From: Simon Davis
Sent: 31 July 2018 10:36
To: 'Richard Goodall'
Subject: RE: P/43/18/DOC Sefter Farm

We have just had a comment from our Landscape officer to say: "The information provided in Constructed Wetland Draft Layout dwg 017 rev 07 details an indicative screen

client	BARFOOTS OF BOTLEY LTD.		
project	Proposed Production Facility Setter Farm		
title	Constructed Wetland Draft Layout		
date	scale @ A1	drawn	chkd
Sep. 2017	as shown	GBC	
project no.	drawing no.	rev	
1603	017	07

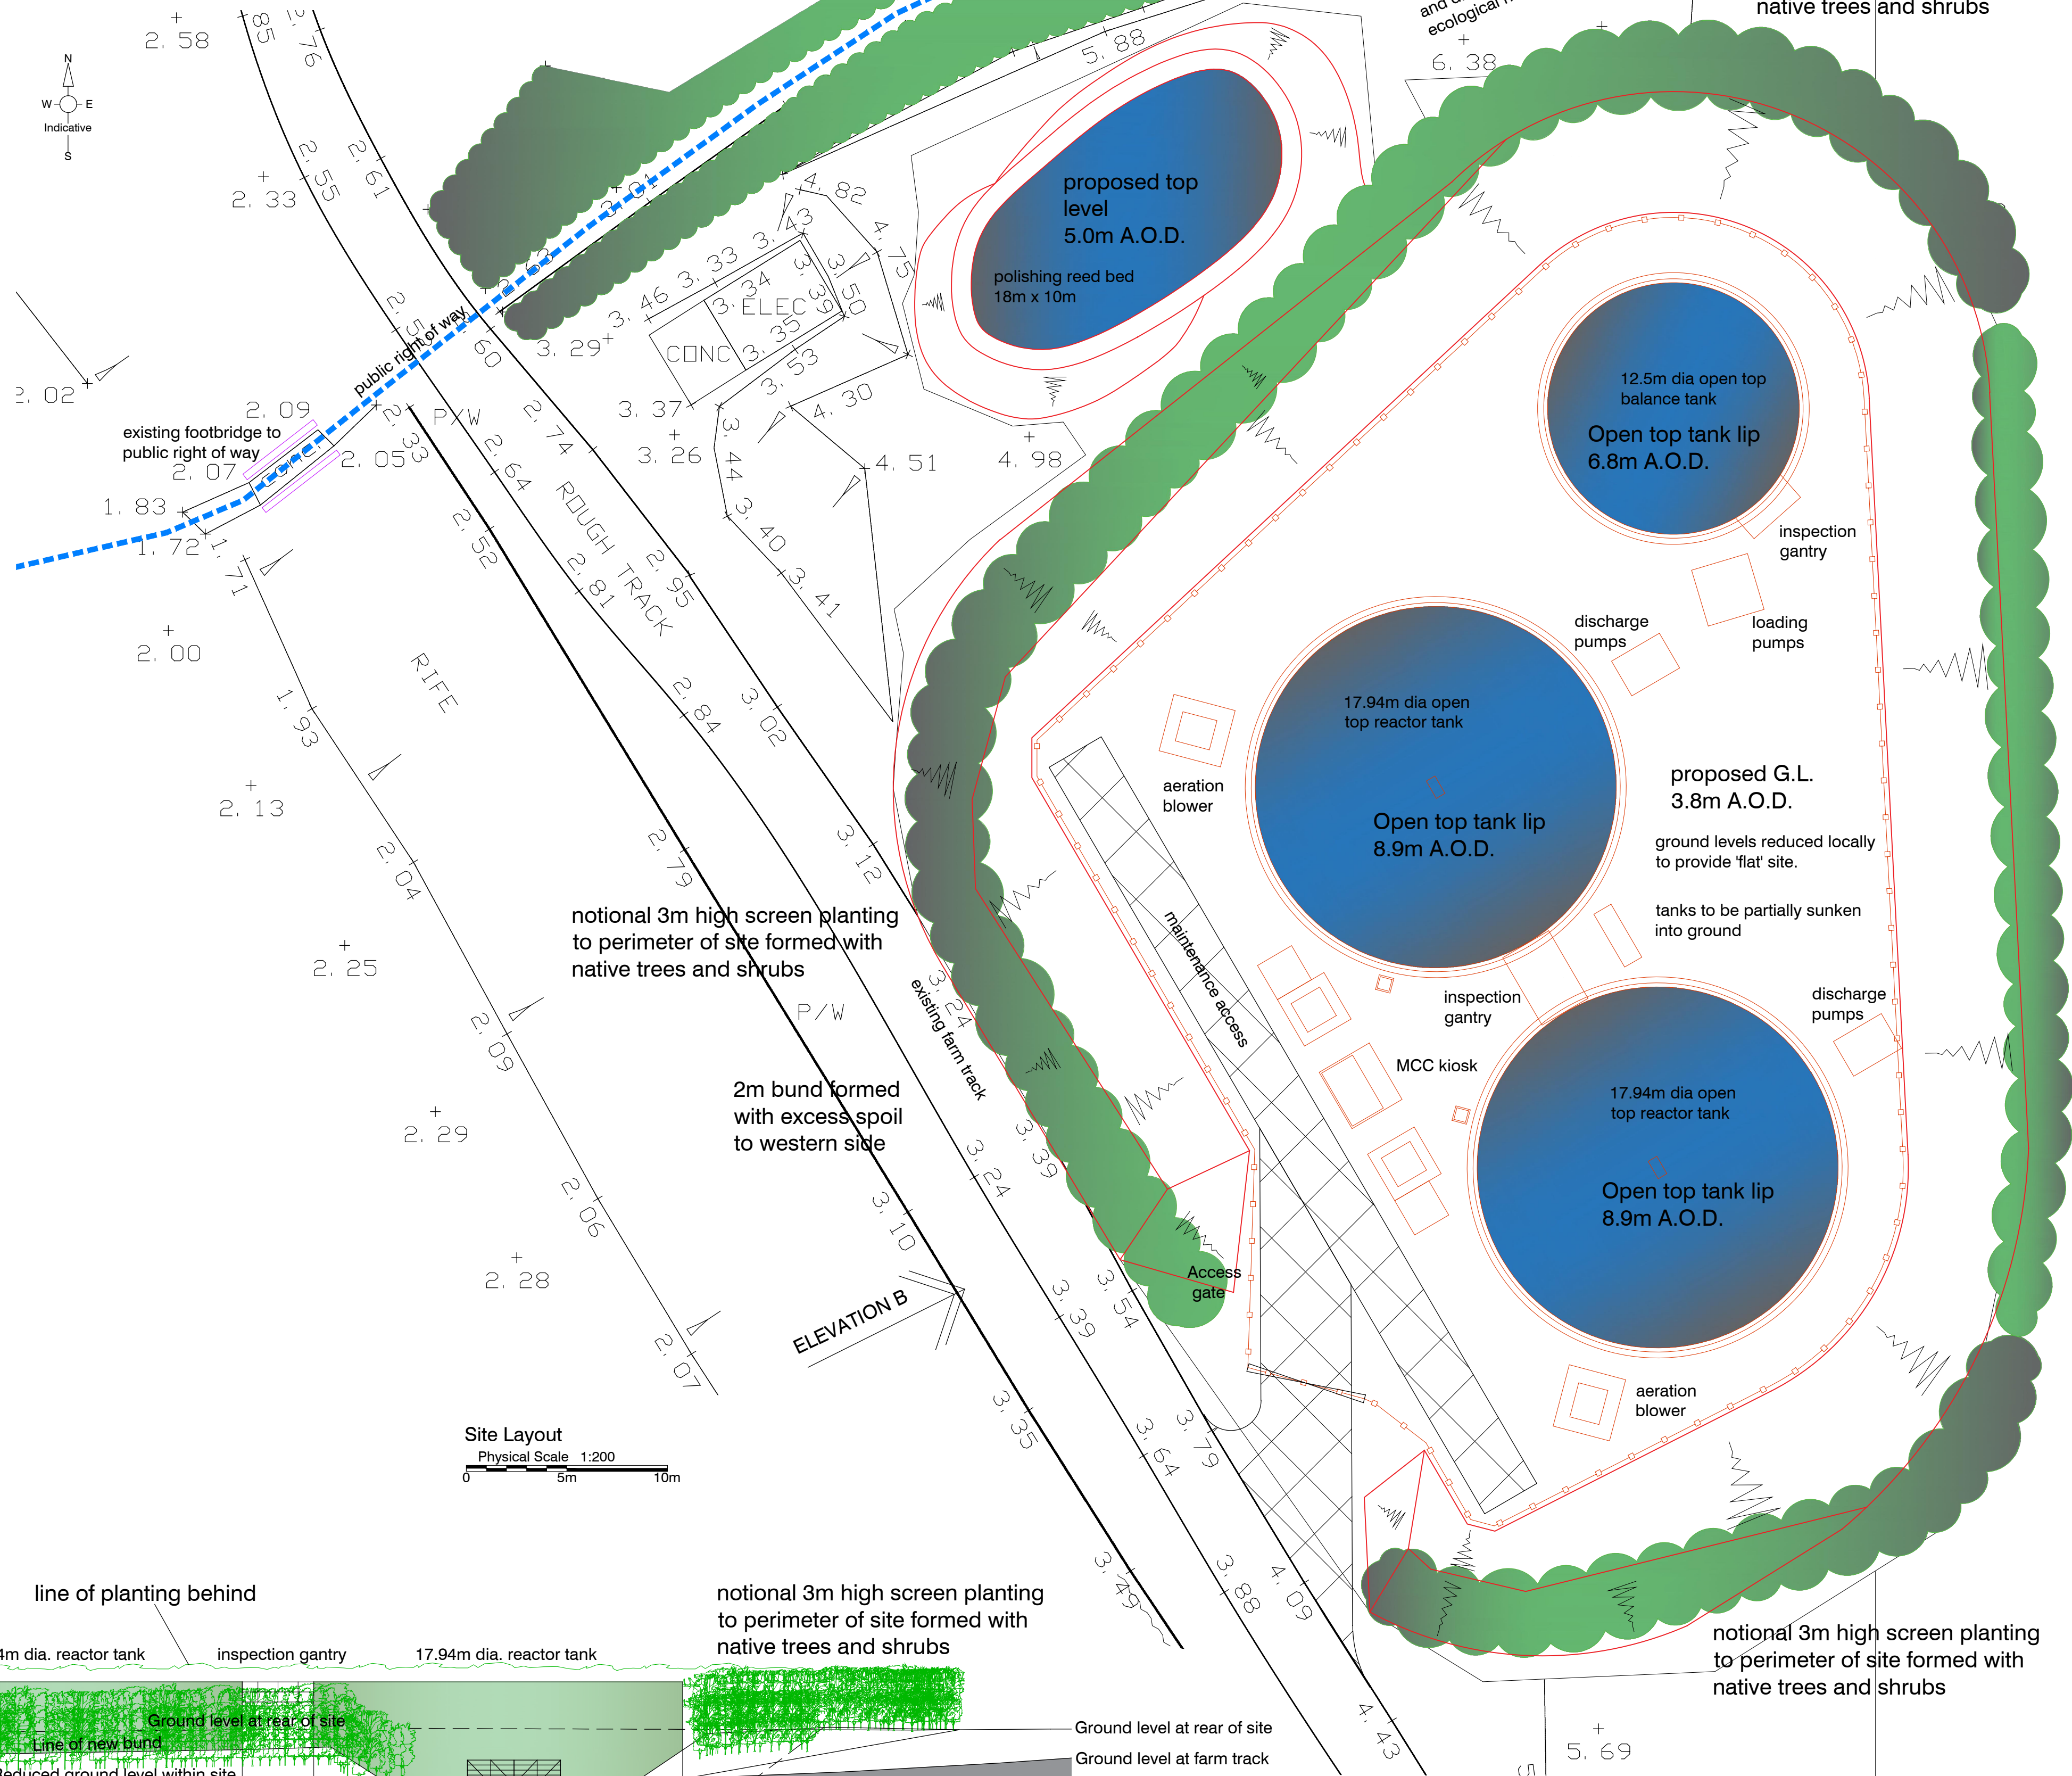
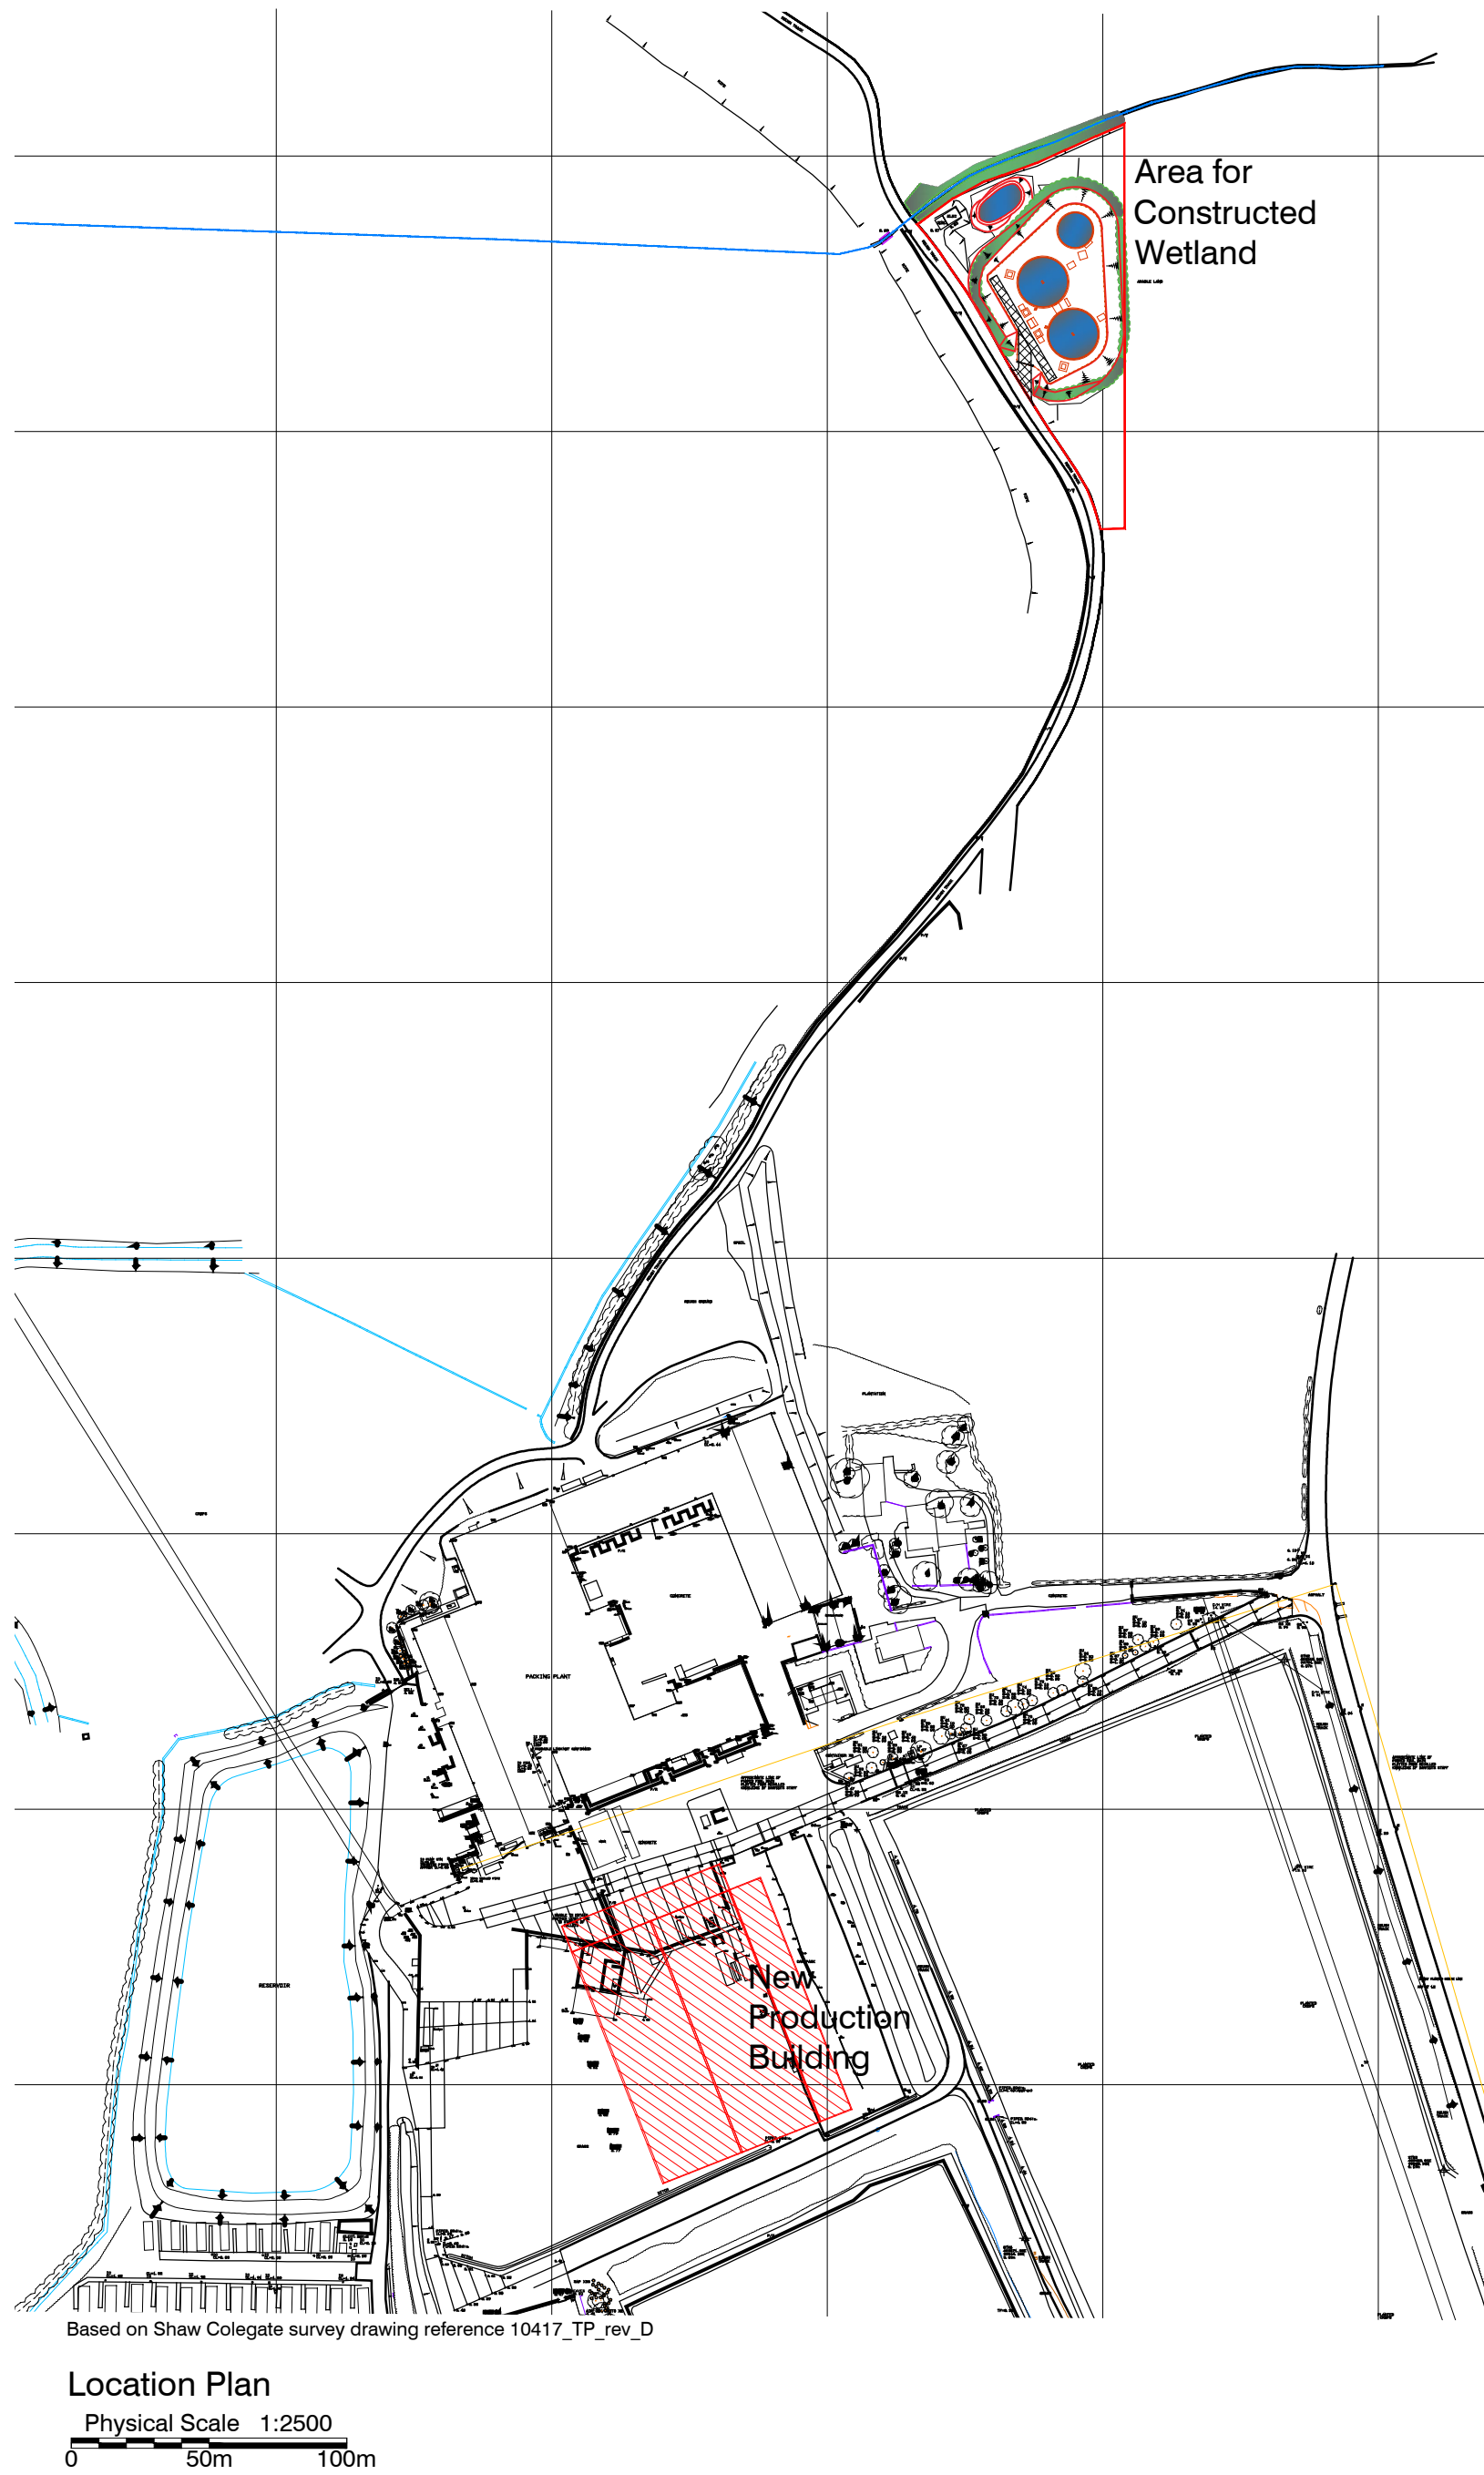
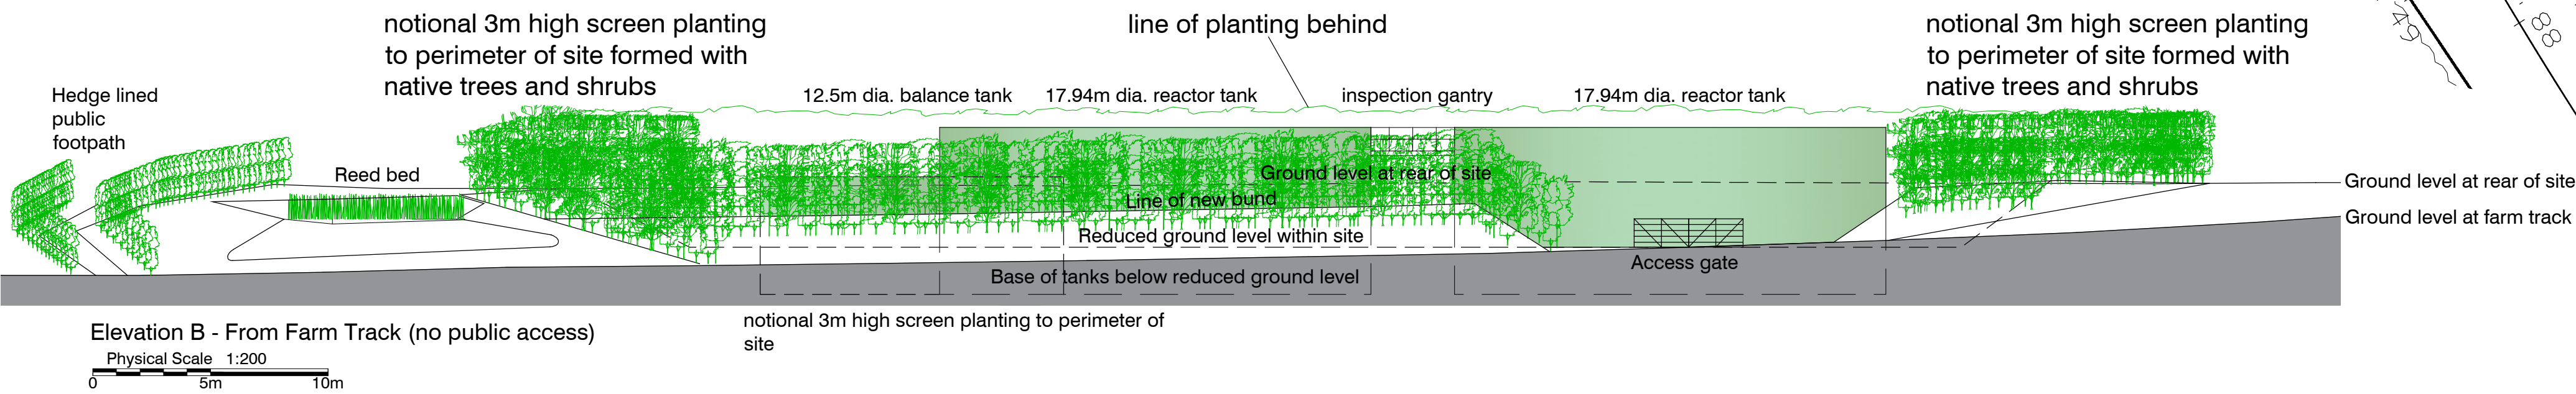
planting to the perimeter which is shown as native planting. Whilst this is suitable for location the detail is not sufficient enough and needs to detail in plan form actual species choice, planting density and size at time of planting. This information needs to be submitted for approval before condition 11 re Landscaping can be considered for discharge. We would therefore not recommend the discharge of Condition 11 landscape scheme until the above information has been submitted for approval.

There are no objections from our ecologist or Nat England but I would request that the drawing be changed as per the above before we can determine this. I look forward to hearing from you.
